Phone: 0300 123 6780
Email: developeras@lancashire.gov.uk
Your ref: 3/2025/0836
Our ref: 3/2025/0836/HDC/KW
Date: 15 December 2025

Location: 2 Harewood Avenue Simonstone BB12 7JB
Proposal: Proposed two-storey side extension to extend existing bedrooms and bathroom at first floor and new roof canopy to the front.
Grid Ref: 377111 434587

H.A 2 / 5

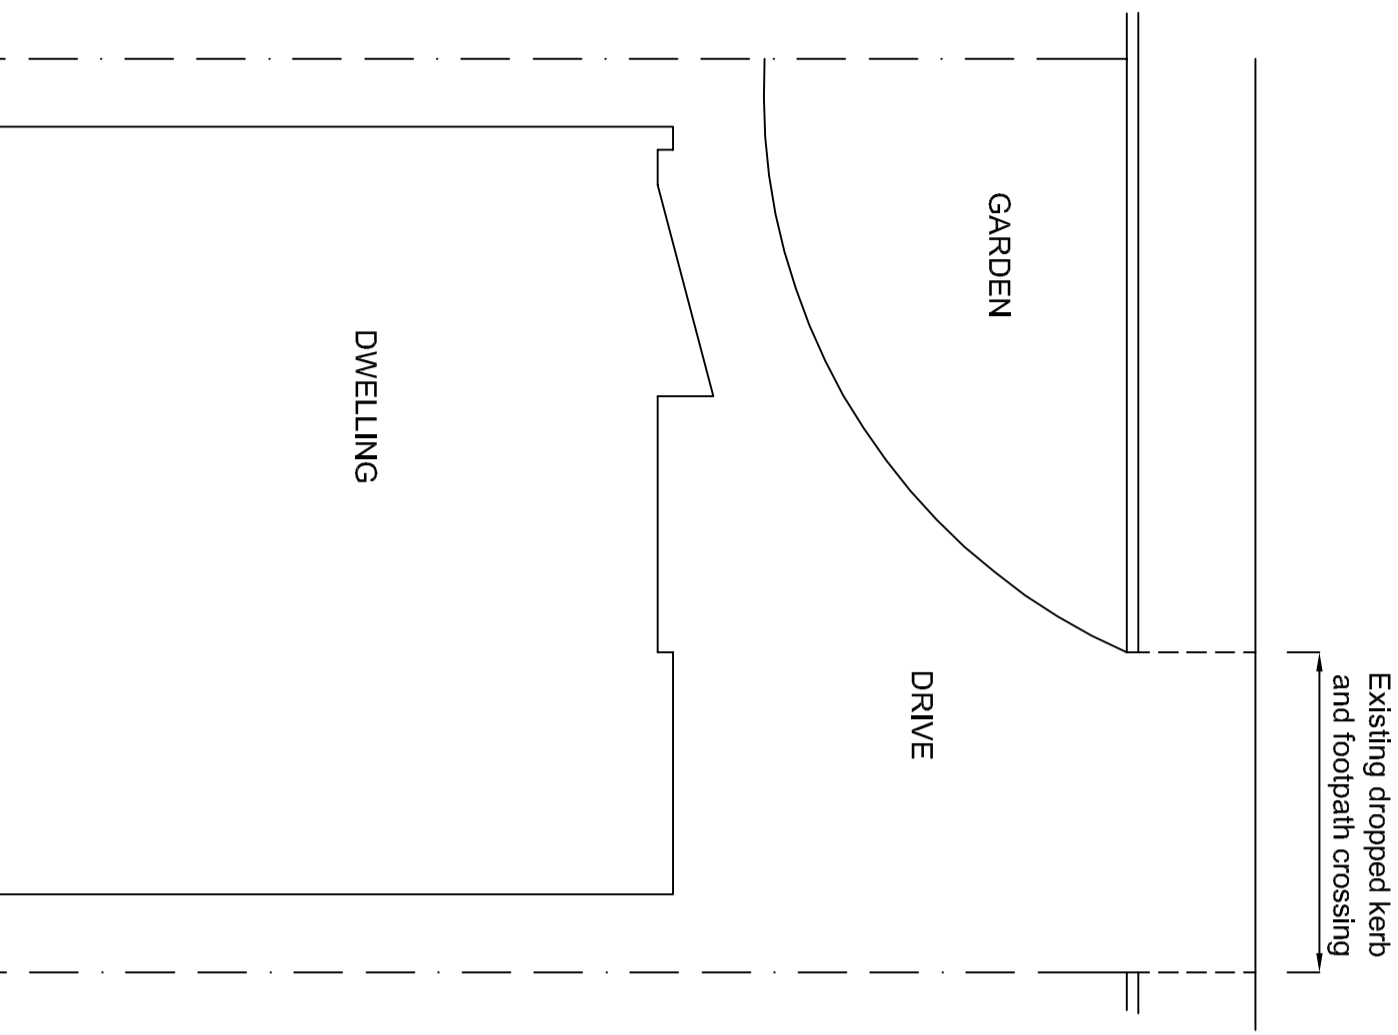
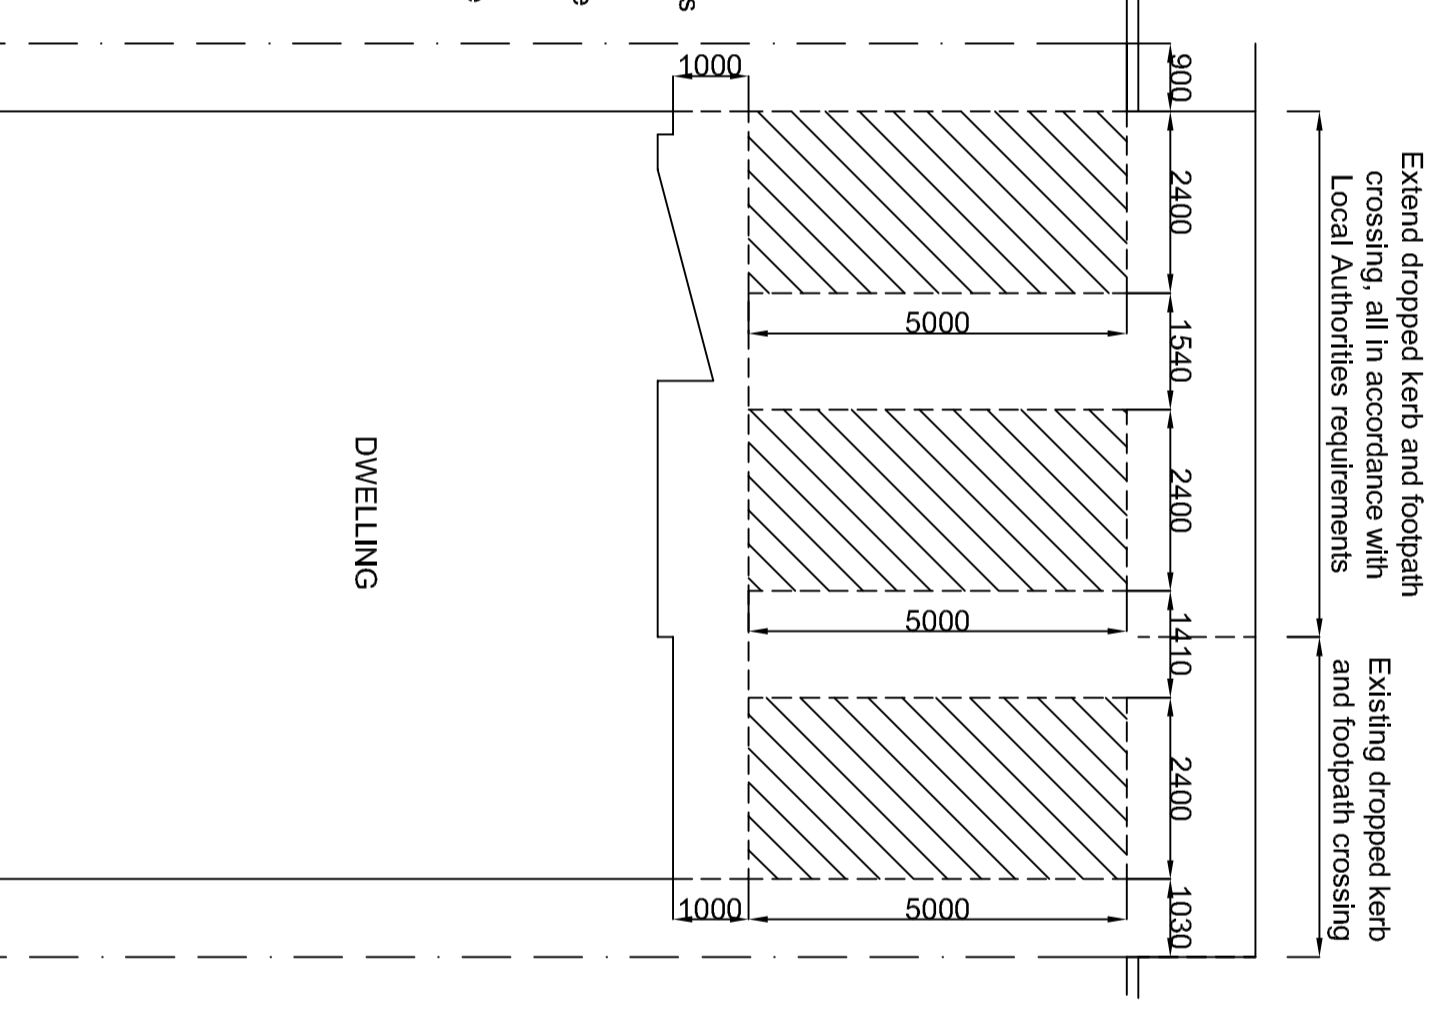
The proposed amendments to the parking area as shown on drawing H.A2/5 are acceptable and will ensure the development has adequate off-street parking provisions. As the area is accessed from the adopted highway it must be properly consolidated and surfaced in bound porous materials, not loose stone, gravel or grasscrete. It will also require the applicant to extend the vehicle crossing across the entire parking area under a Section 171 Agreement of the Highways Act 1980.

It should also be noted that there is a utility chamber situated within the proposed vehicle crossing; the applicant will need to discuss the relocation of the chamber directly with the utility company.

1. Before the parking areas are used for vehicular purposes, they shall be appropriately paved in tarmacadam, concrete, block paviments, or other hard material to be approved by the Local Planning Authority. Reason: To prevent loose surface material from being carried on to the public highway thus causing a potential source of danger to road users.
2. The surface water from the approved driveway shall be collected within the site and drained to a suitable internal outfall. Prior to commencement of the development details of the drainage strategy shall be submitted to and approved in writing by the Local Planning Authority. The scheme shall be implemented in accordance with the approved details. Reason: In the interest of highway safety to prevent water from discharging onto the public highway.
